August 24, 2022

**Re: Kairos Power – 5102 Hawking Dr. SE
Erosion and Sediment Control Plan
Engineer's Stamp Date (missing) (Q16E5000A)**

Based upon the information provided in your submittal received 8/19/2022, the above-referenced ESC Plan cannot be approved until the following comments are addressed.

C6

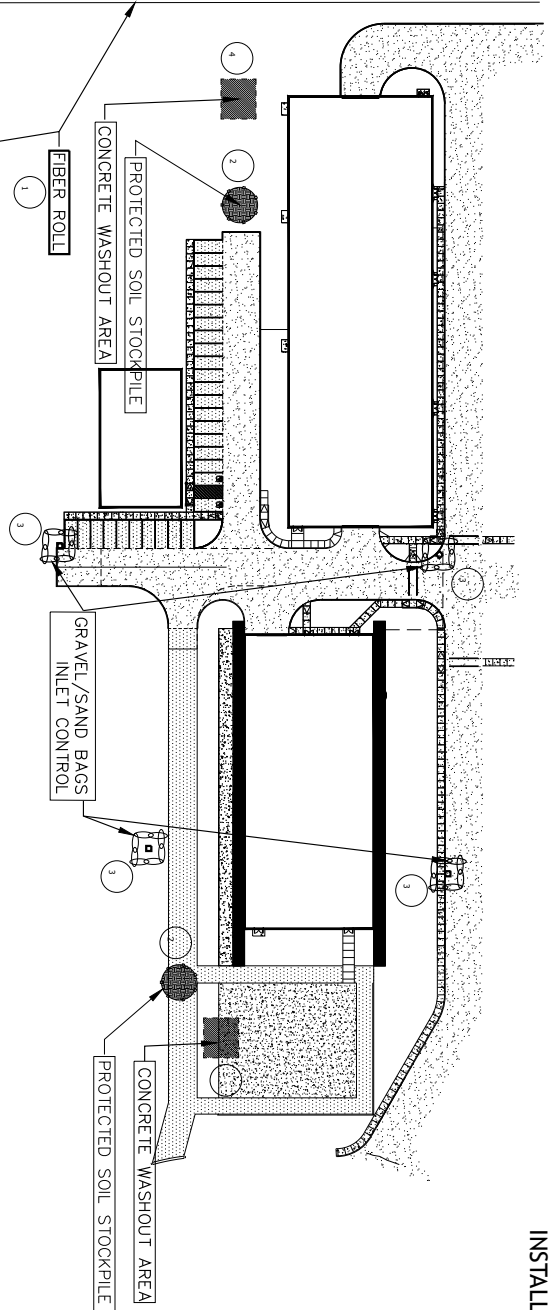
2. The property lines and limits of disturbance must be shown clearly on the plan. Show designated points where vehicles will exit onto paved roads (CGP7.2.4.a & b)

3. I can't tell the difference between building, sidewalk, asphalt, and dirt on the ESC Plan. These structures must be clearly identified in the SWPPP per CGP 7.2.4.b.vi. The same information is required in the ESC Application. You may attach a copy of the Site Plan to both the SWPPP and the ESC Application to address this requirement.

4. Describe undisturbed and pre-construction ground cover (CGP7.2.4.e)
5. Identify locations of concentrated flow paths that enter and exit the disturbed areas. Identify locations where sheet flow enters and exits the disturbed area. Show on-site drainage patterns of stormwater before and after major grading activities. (CGP 7.2.4.f)

ESCP 1

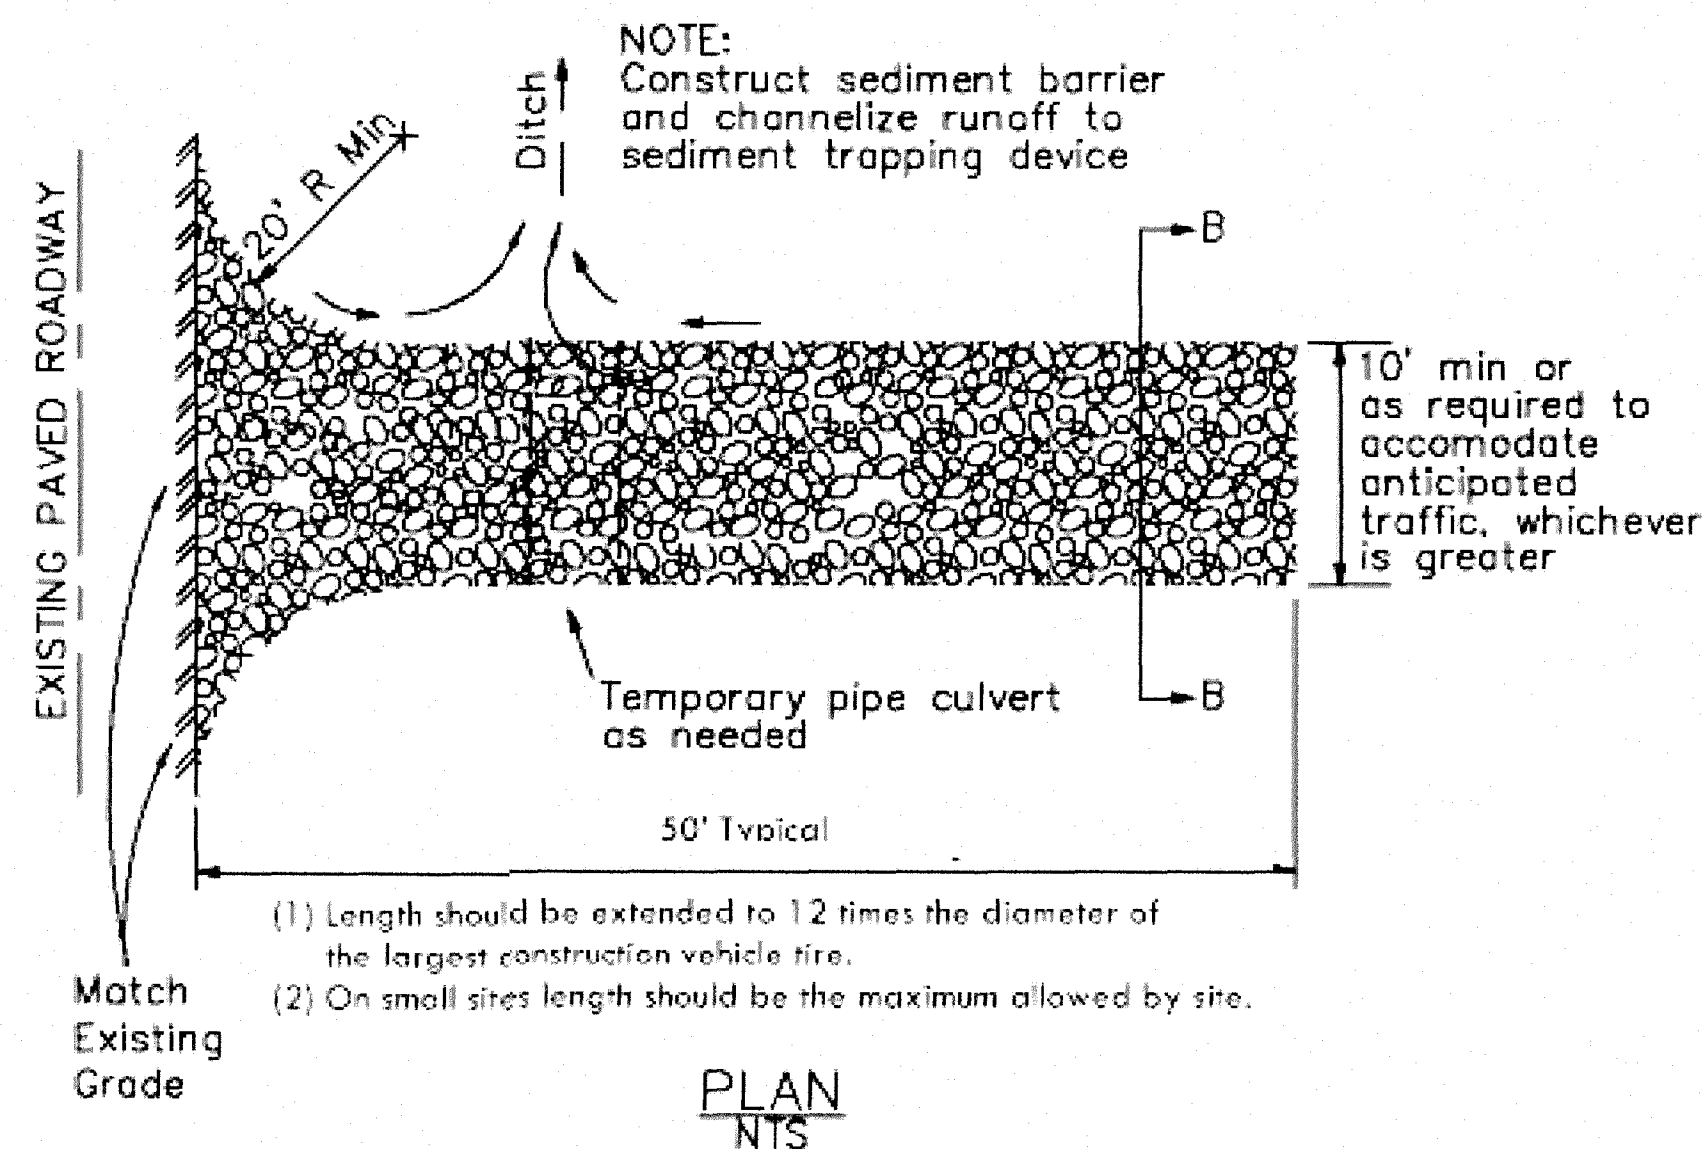
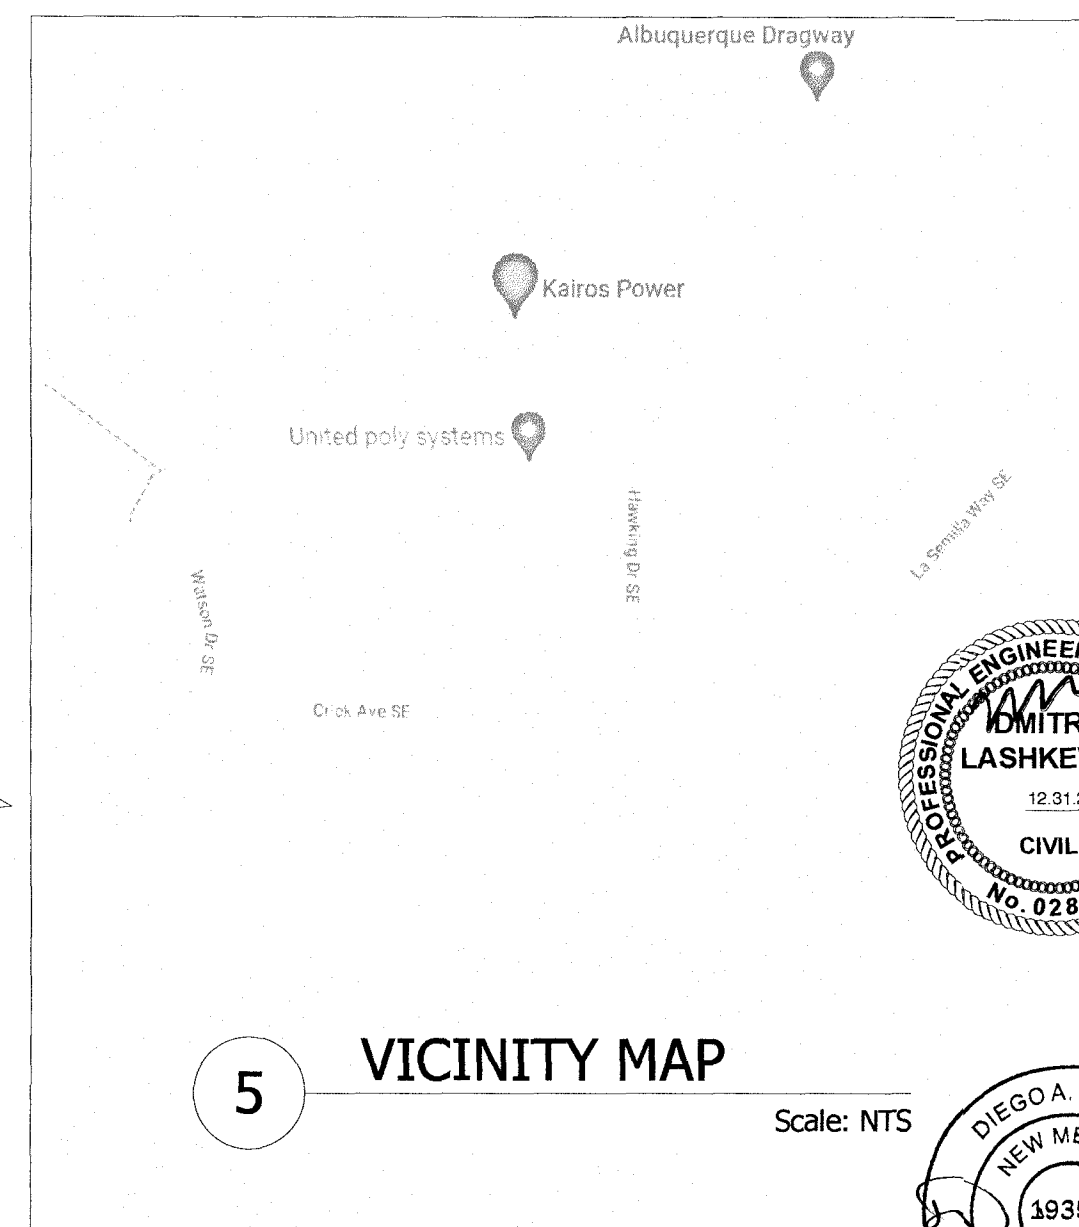
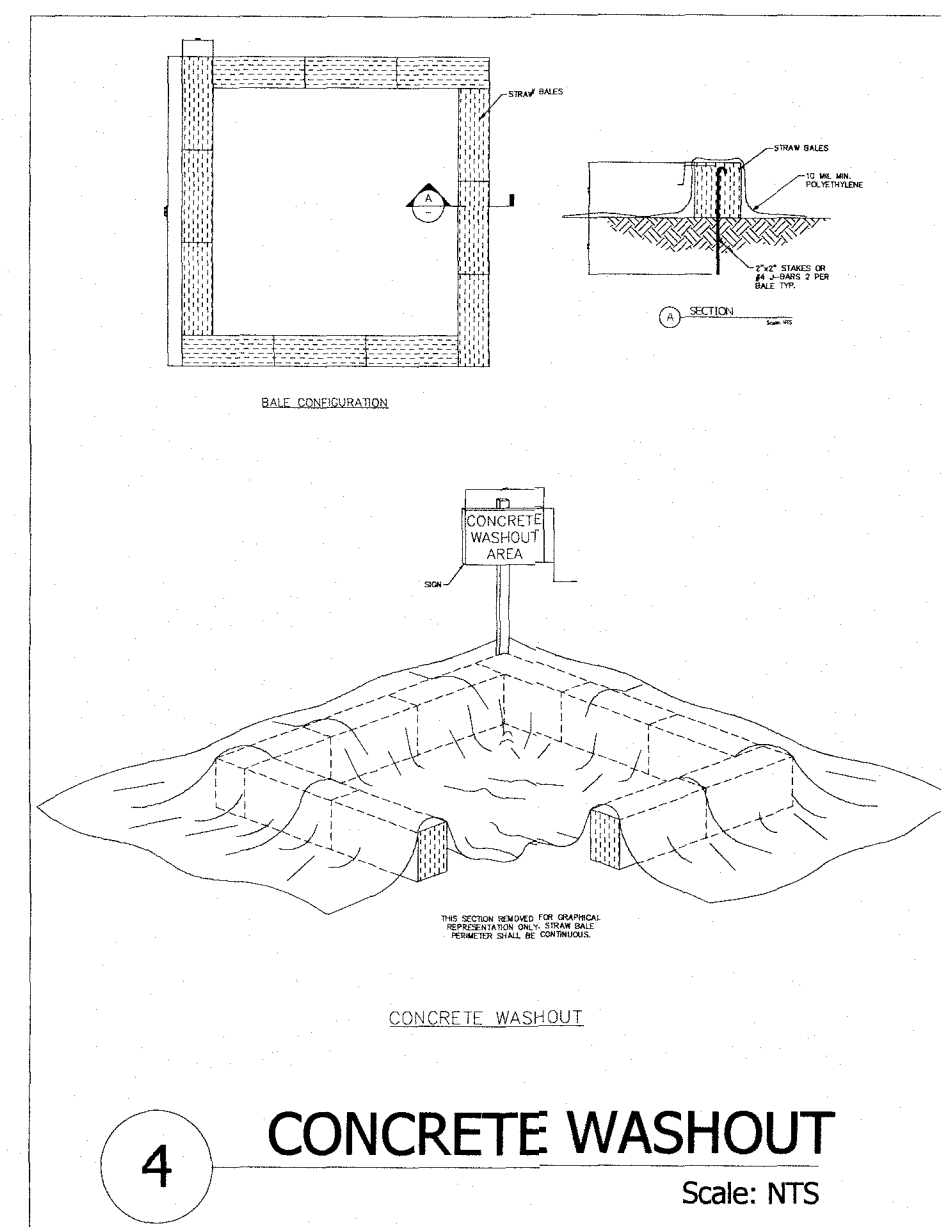
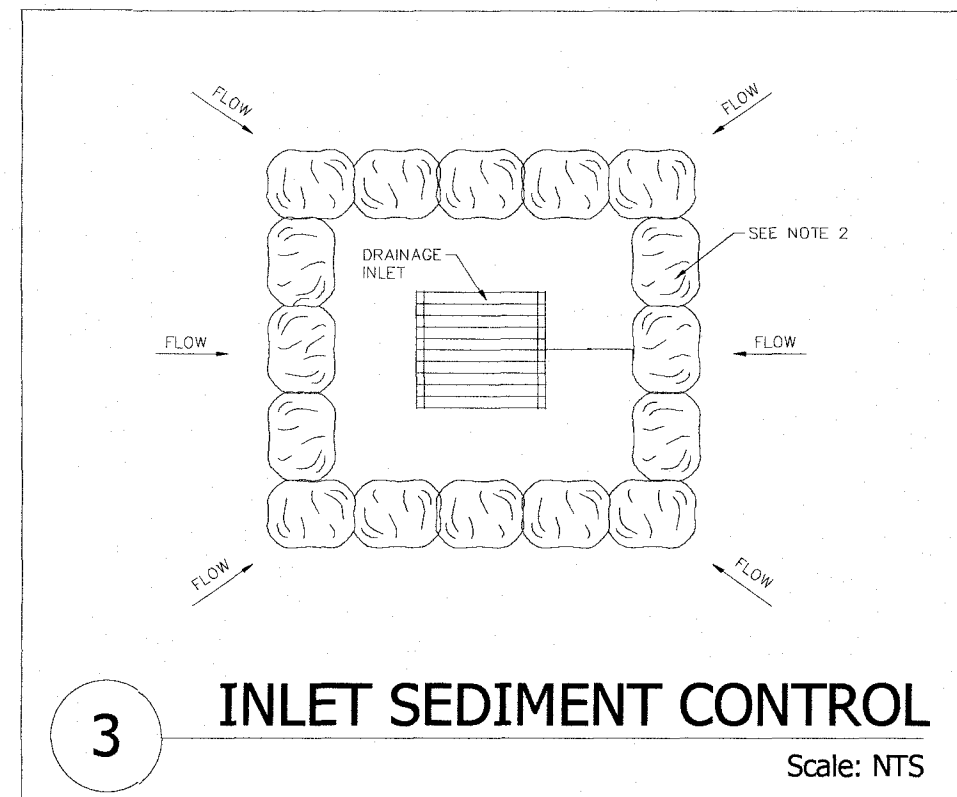
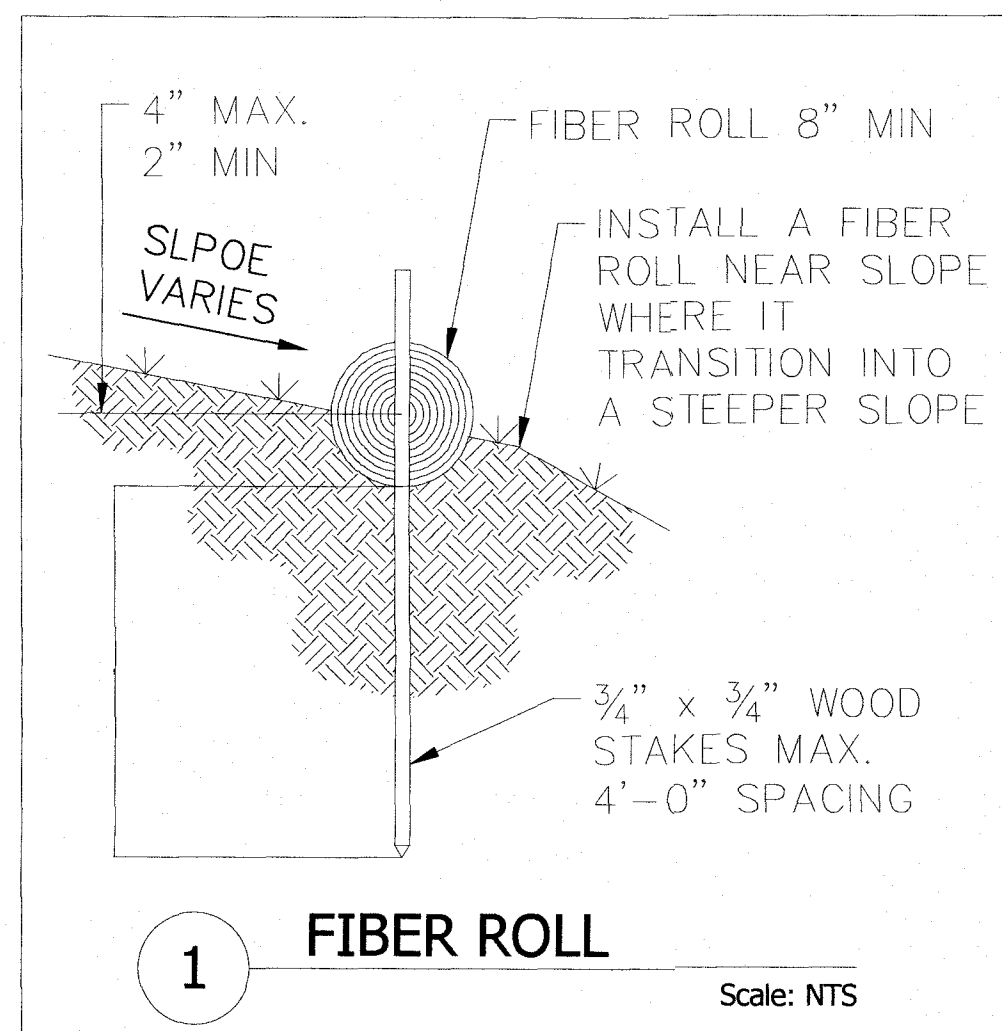
7. The ESC Plan can't be approved for Building Permit until the property owner's NOI has been reviewed and approved by City Stormwater Quality per Albuquerque Code § 14-5-2-11(a). Provide deeds, leases, easements or additional NOIs from the property owners, "The City of Albuquerque" and "Steve Chavez, Rudy Guzman, and Pete and Soula Daskalos".
8. City Standard ESC Notes are attached.
9. Provide Engineers certification. Update the engineer's stamp date each time the plan is changed.
